One Earth Solar Farm

**Draft Statement of Common Ground with Newark and
Sherwood District Council**

EN010159/APP/8.6.3

November 2025

Drawing Number:  
EN010159/APP/6.20/10.1

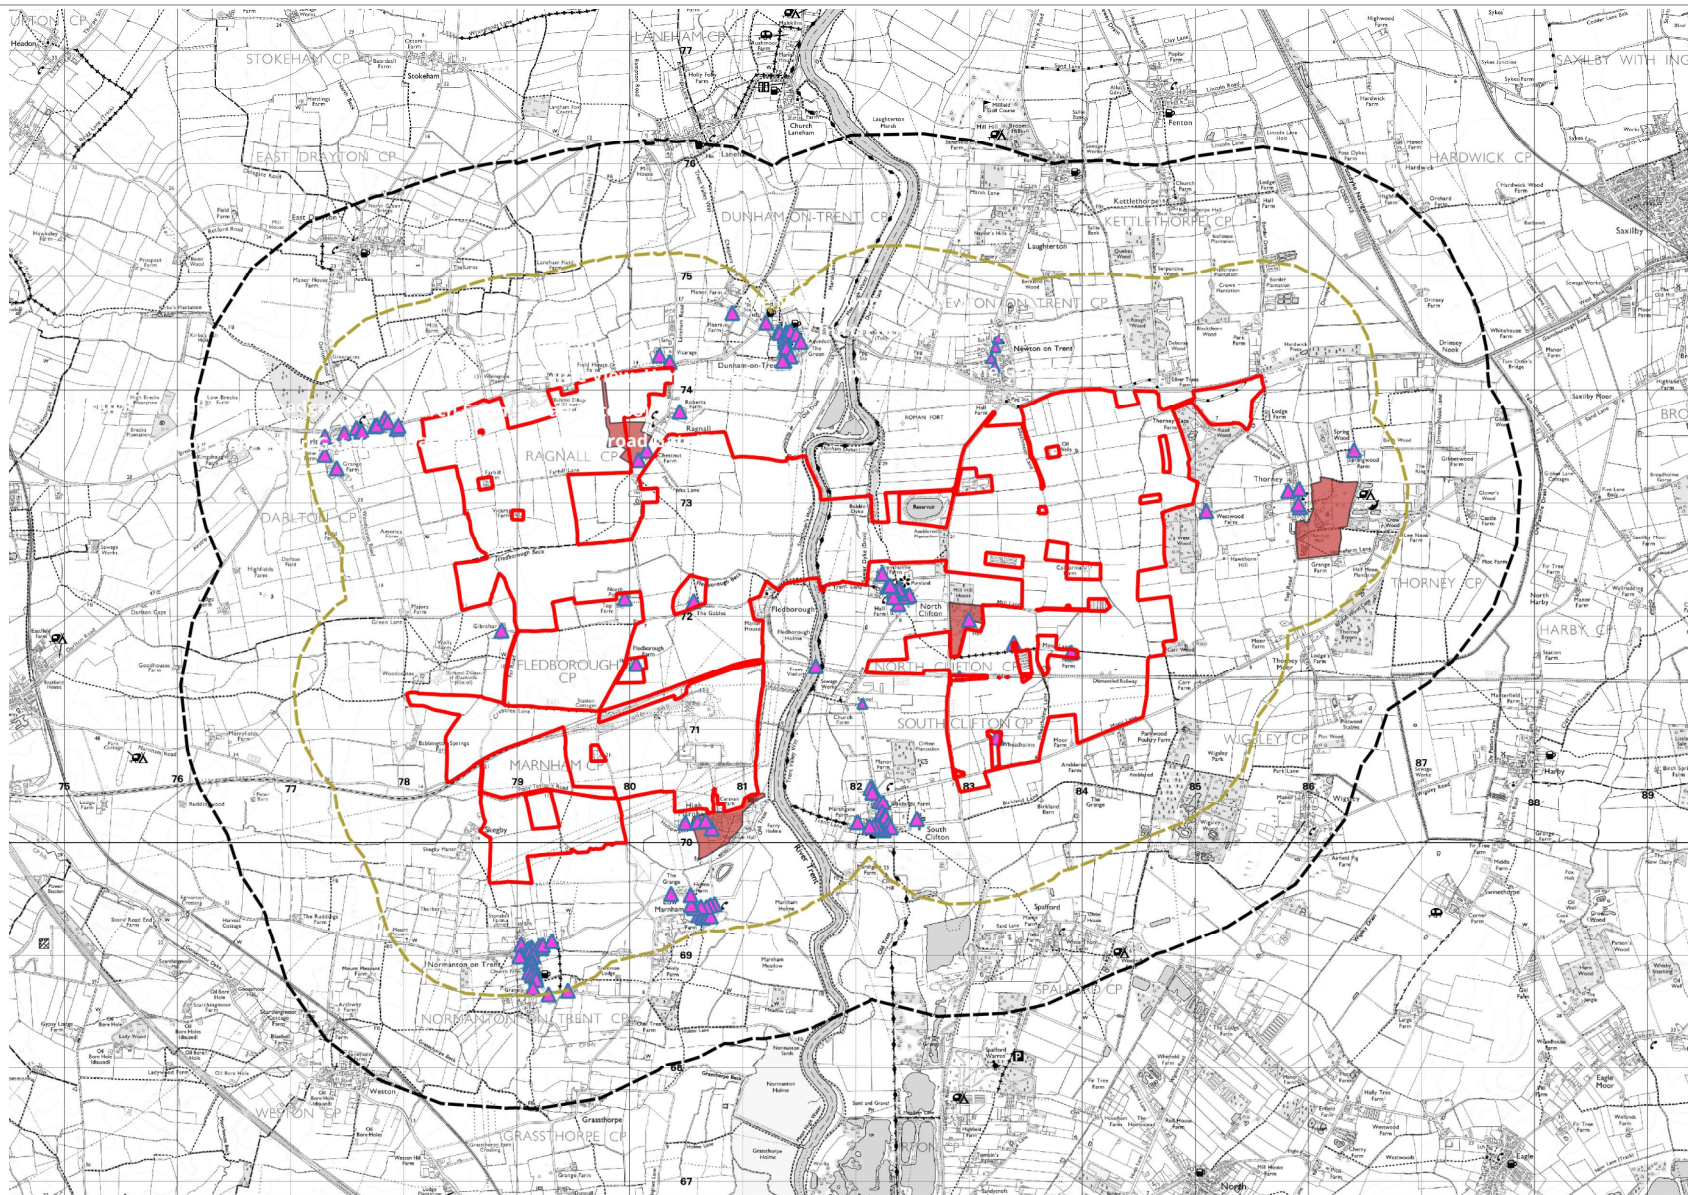
Further detail can be found in the Applicant's Response to Relevant Representations [REP1-075]	
02-08	Firs Farmhouse (Grade II)	Small strip of the solar farm seems encroach towards the heritage asset	Figure 10.1 [APP-055] of ES Chapter 10 [APP-039] confirms that the Order Limits stand at c.930m to the west of this asset. There is no stretch of the Order Limits which stand within the vicinity of the asset and no harm will arise. Further detail can be found in the Applicant's Response to Relevant Representations [REP1-075]	Agreed
02-09	Hall Farmhouse (North Clifton. Grade II, NHLE: 1302529)	There may be possible views from this heritage asset.	As illustrated within Viewpoint 25a (Figure 11.13.7 ^a [APP-068]) and assessed at paragraph 10.6.96 of ES Chapter 10 (ref. APP-039), the Order Limits would stand distant from the asset and hold no intervisibility.	Agreed
02-10	Trent Lane Farmhouse (North Clifton. Grade II, NHLE: 1369937)	There will be views in nearby field. Recommended mitigation suggest increased hedging to the south of the heritage asset.	The Order Limits would stand at distance from the asset (over 280m to the north), would not backdrop views of this asset from the Viaduct, and would hold no adverse effect on the appreciation of the asset as an agriculture farmhouse.	Agreed

**Zone of Theoretical Visibility**

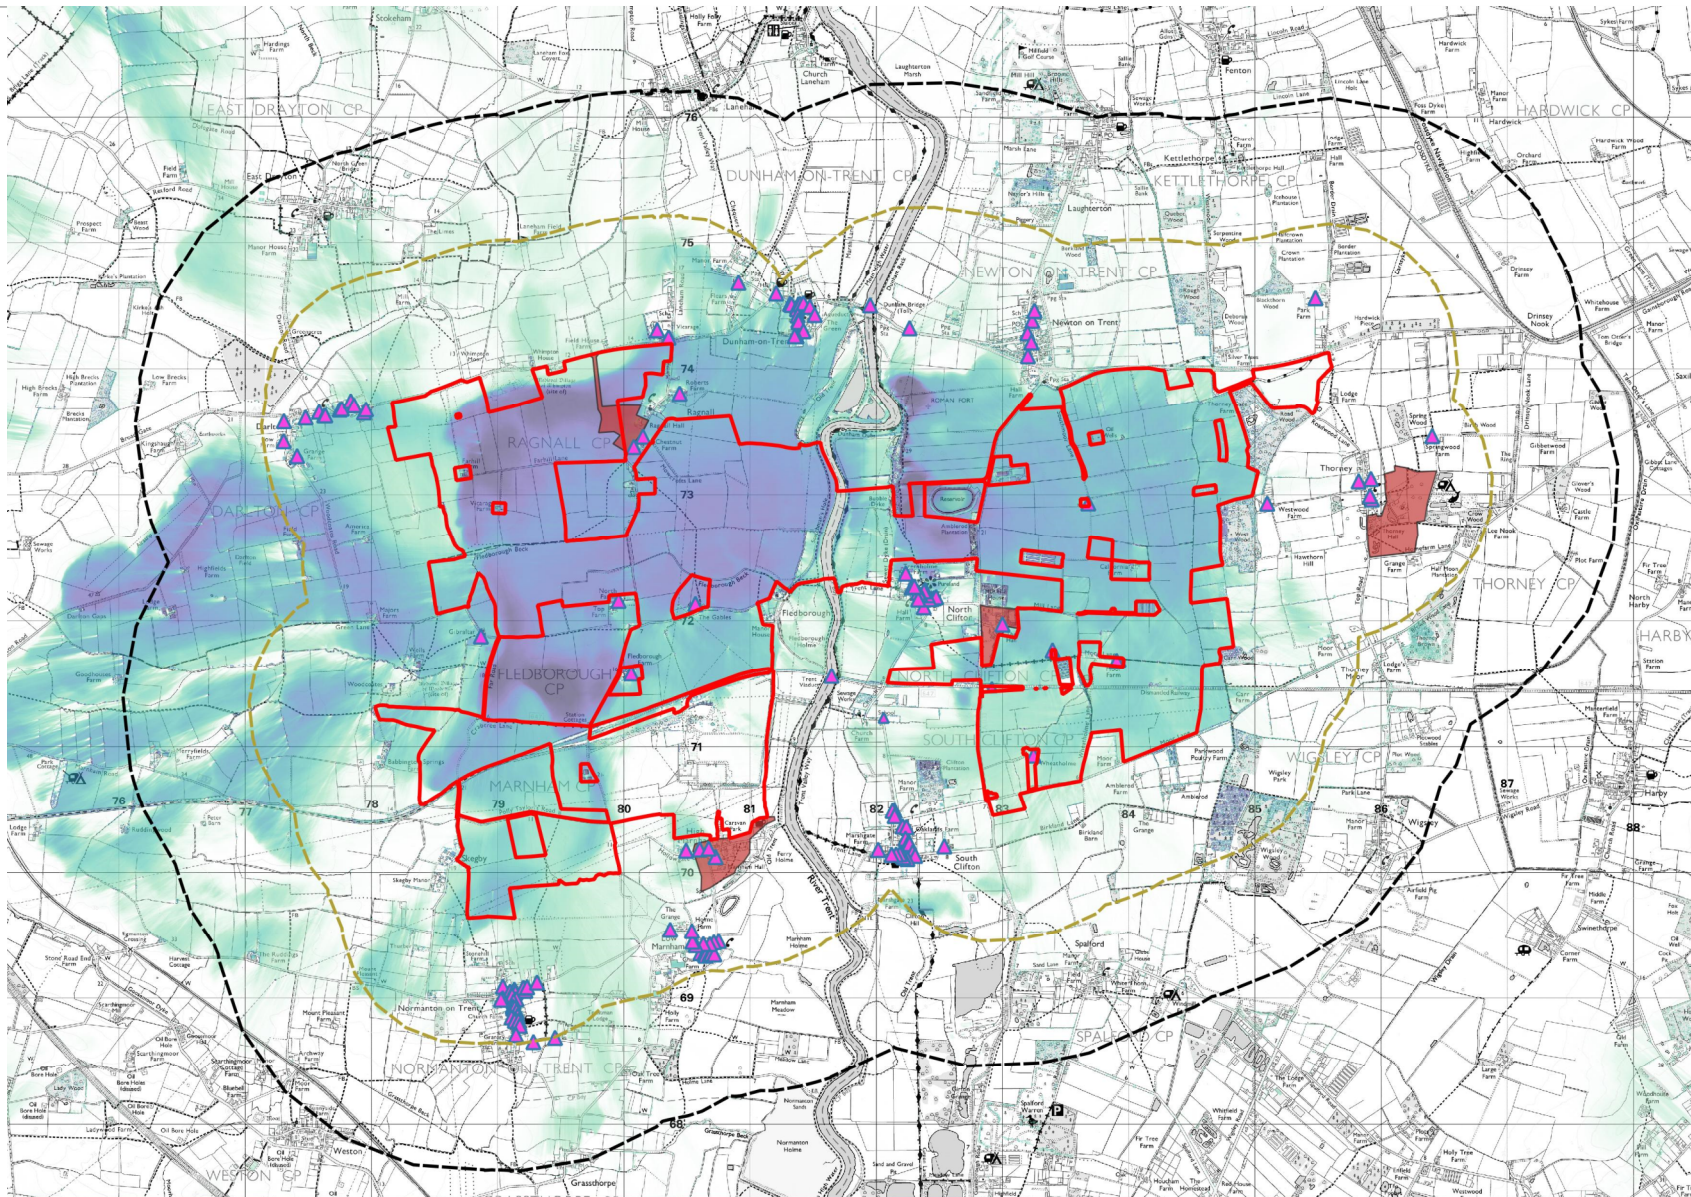
02-04	Perceived impact to Church of St George the Martyr and Church of St Helen	Further consideration required on setting of both assets and further mitigation required – specifically for the impact on Church of St George the Martyr, and Church of St Helen.	<u>Church of St George the Martyr</u> Effects of the Proposed Development on St George the Martyr are located within paragraphs 4.136 – 4.139, page 66 of Technical Appendix 10.3 [APP-128] and paragraphs 10.9.9 and 10.6.98.100 of ES Chapter 10 [APP-039]. <u>St Helen Church</u> This asset has been assessed in ES Chapter 10 (ref. APP-039) at paragraphs 10.6.7 and	Agreed

02-06	Lychgate at Church of St George	“Impact of proposal This listing would not be as impacted as the Church of St George due to its location, but it still forms part of the wider setting.... Recommended Mitigation None would be required for this heritage asset.”	The Zone of Theoretical visibility (Figure 10.3 [APP-055]) confirms no intervisibility of the Proposed Development. There would be no effect on the appreciation of the church, churchyard and lychgate Therefore, this asset would not change the assessed effects (or lack thereof) on the Church of St George the Martyr (Grade II*). Further detail can be found in the Applicant’s Response to Relevant Representations [REP1-075]	Agreed
02-07	Fledborough Viaduct	The impact of solar panels either side would be detrimental to the wider setting of the viaduct.	No solar arrays are to be located on either side of the viaduct as the land is not included within the Order Limits. It is unclear which northern small parcel is recommended for removal; to clarify the nearest Order Limit north of the Site is at c.660m. As noted within paragraphs 10.6.68 – 10.6.71 of ES Chapter 10 [APP-039], the industrial historic interest of the asset is not reliant on views of a particular character of the landscape to understand its value. The Proposed Development would hold a negligible neutral effect and result in no change to the contribution of the wider setting to asset’s value.	Agreed

02-13	Cottage at Thorney Hall (Thorney.	Suggestion to increase hedging to the south of the asset for mitigation.	Figure 10.3 [APP-055] confirms that there would be no intervisibility with the Order Limits. The Proposed Development would not affect the value (significance) of	Agreed

10.6.126, in paragraph 4.191 of the Technical Appendix [APP-128]. The Zone of Theoretical Visibility mapping [Figure 10.3 (APP-055)], the Proposed Development would hold no visibility. Further detail can be found in the Applicant's Response to Relevant Representations [REP1-075]	
02-05	Ruins of Old Church in Churchyard	Recommendation of further mitigation to protect any views.	This asset has been assessed in ES Chapter 10 (ref. APP-039) at paragraphs 10.6.7 and 10.6.126 and on page 85 of Appendix 10.2 (grouped with other assets in Thorney, as agreed with stakeholders – see Table 10.5 [APP-128]). The Zone of Theoretical Visibility, there would be no impact to the value (significance) of this asset, further mitigation is not required as no harm can feasibly exist which requires screening. Further detail can be found in the Applicant's Response to Relevant Representations [REP1-075]	Agreed
